CITY OF ALBUQUERQUE

June 27, 2011

**Re: Ingersoll Rand Trane
Grading and Drainage Plan
Engineer's Stamp dated 4-15-2011 (B18/D005)**

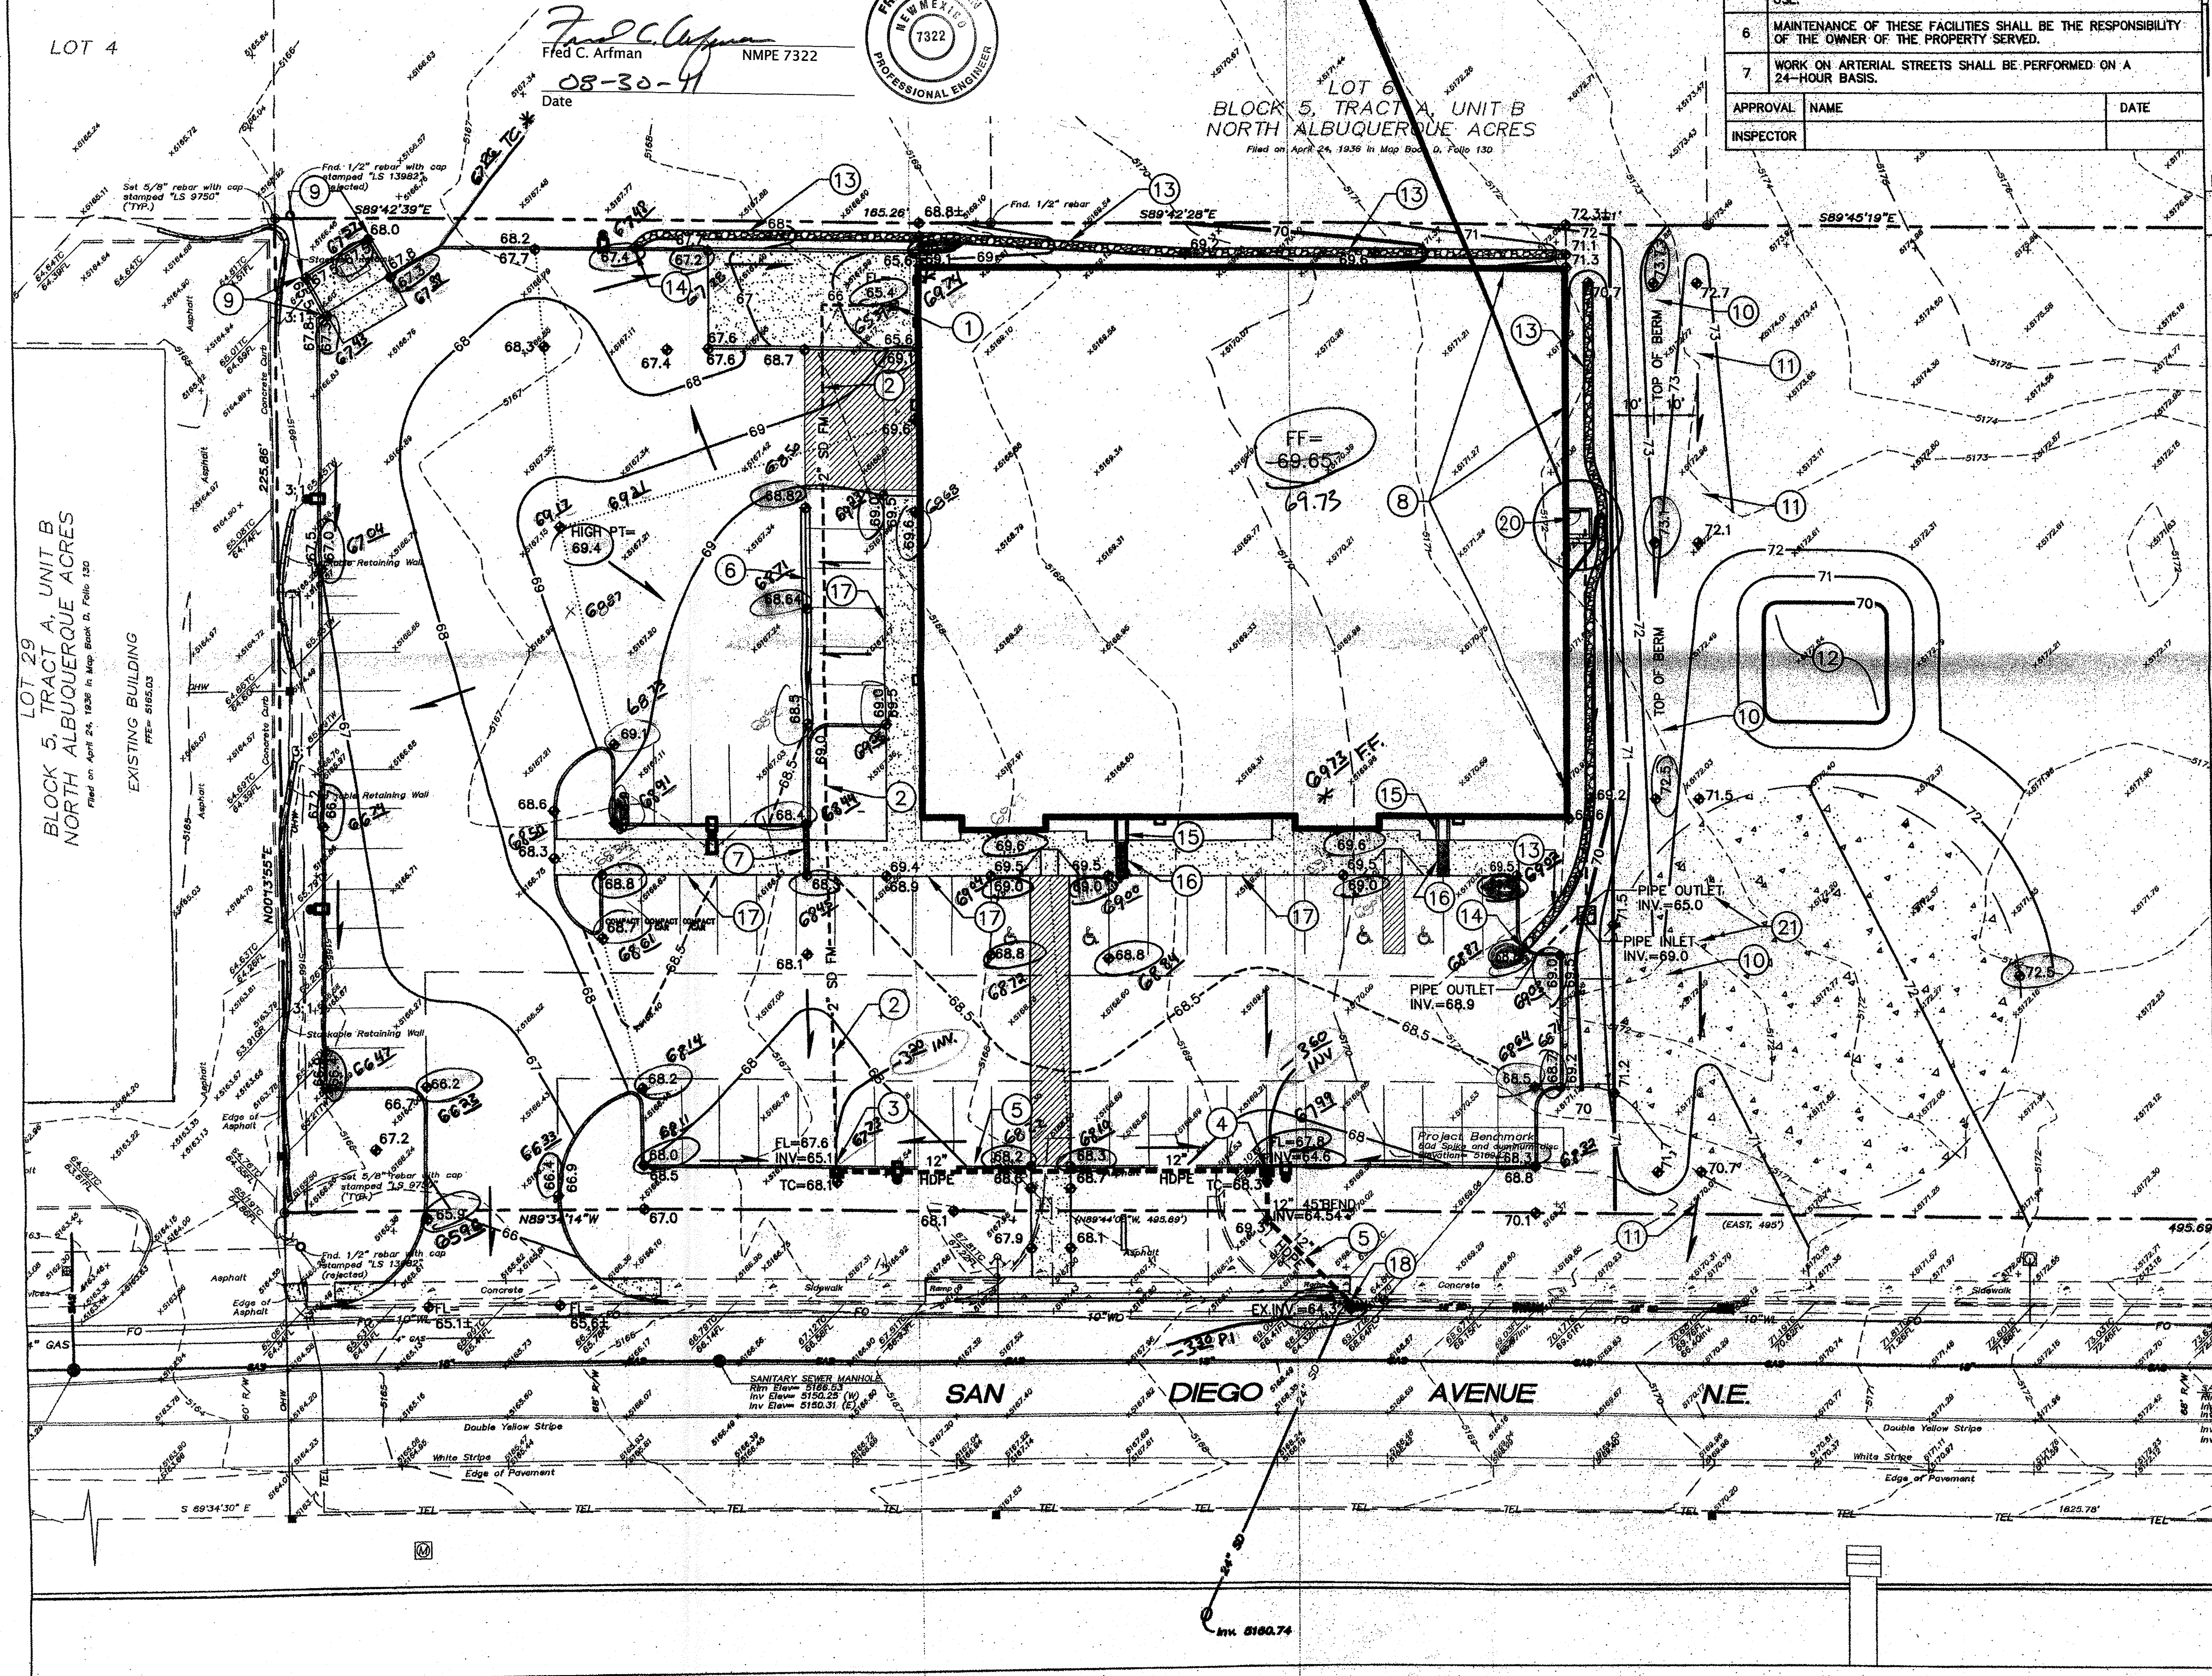
- Provide a pipe connection such as a riser for the drain pipes from the new additional entrance.

Hydrology is requesting that all proposed landscape areas are depressed to retain/infiltrate the moisture that falls on them.
